City of Albuquerque Stormwater Construction Site Inspection Report

ESC File No.	G12E035	Project Name:	Puerta Del Bosque		
NPDES Id. No.	NMR10013N	Location:	Puerta Del Bosque Ln and Campbell Rd. NW		
5/12/2021	Owner	Contractor			
Operator	Sivage Community Development LLC				
Contact name & title	Steve Hernandez				
e-mail	steve@dmcnm.com				
Contact Phone #	505-228-1401				
COA Inspector	Thomas Evans		Start/End Time:	1:25 PM/1:35PM	
Construction Phase:	infrastructure/home construction				
Type of Inspection:	Regular	Storm Event	Past Storm Event >0.25"	311/Complaint Follow Up	
Weather at time of inspection?	clear		Temperature:	~ 75	
Estimated date of last storm 0.25" or greater	5/3/2021

SILT FENCE FOR SEDIMENT CONTROL
N.T.S.

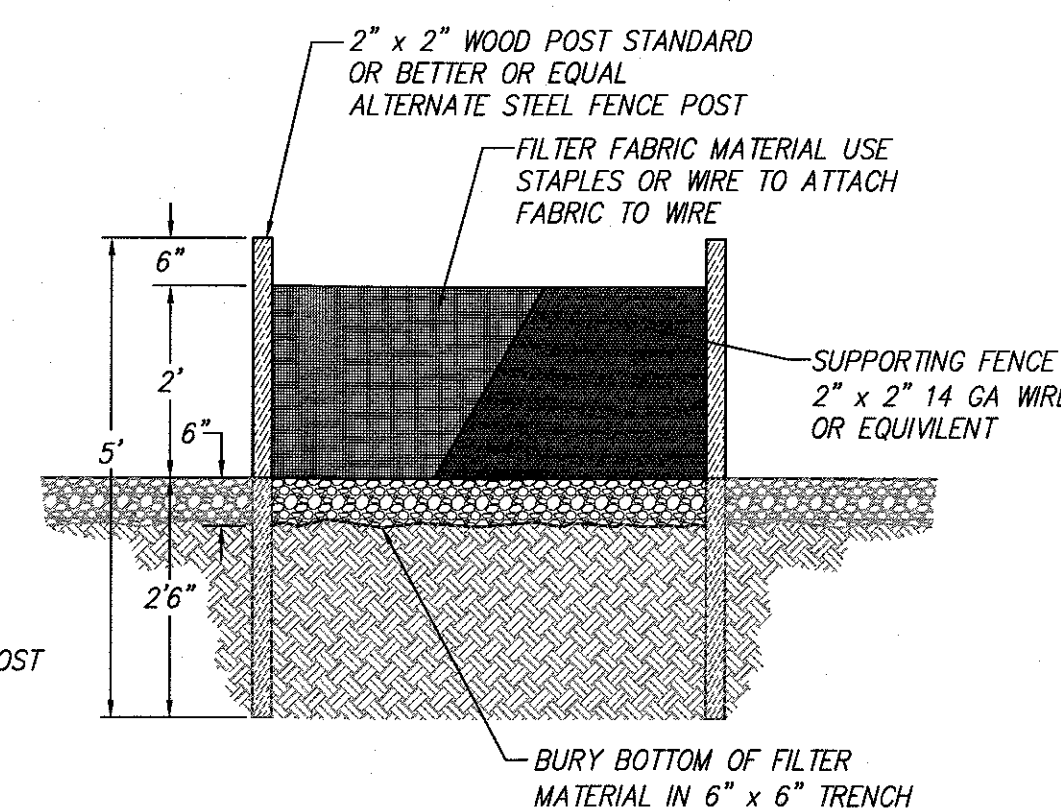
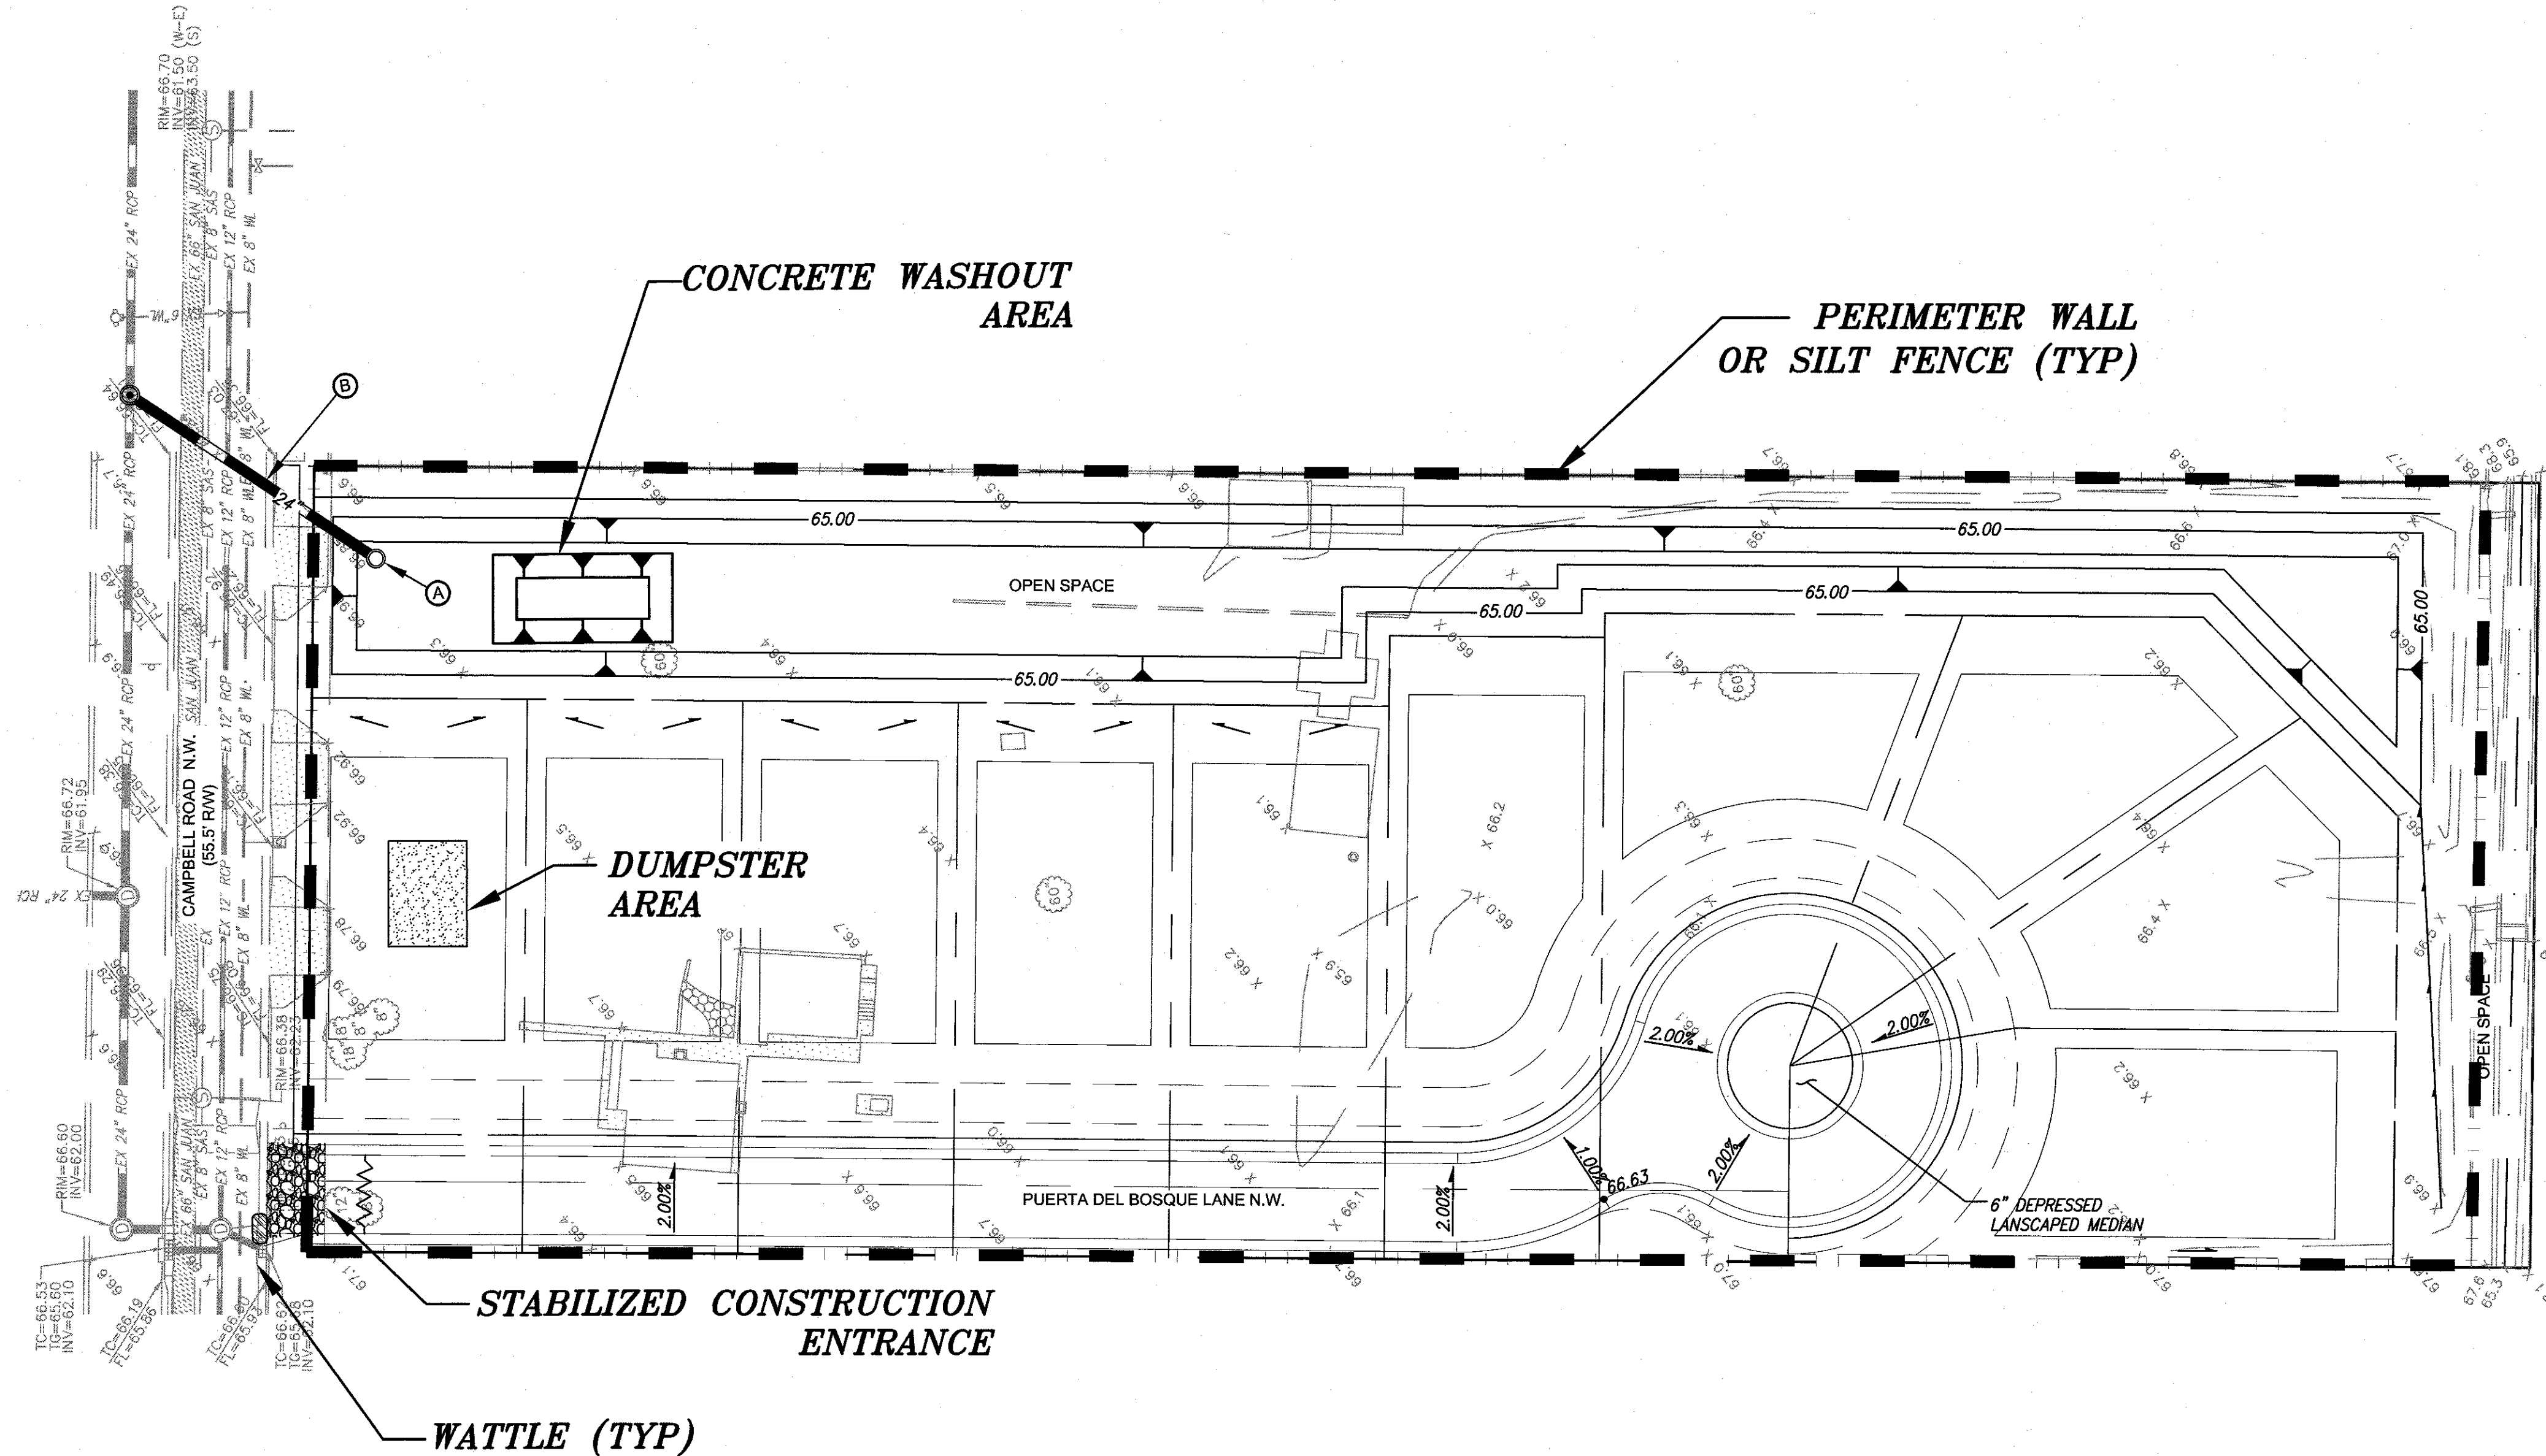
Item Number	Deficiency/ Corrective Action				
1	No posting of permit coverage. CLL sign is up, but the permit notice is not there.				
2	Hole in silt fence. Maintain silt fences to prevent soil from entering the street.				
3	Clean washout area. Remove and dispose of hardened concrete and other waste per CGP 2.2.3.
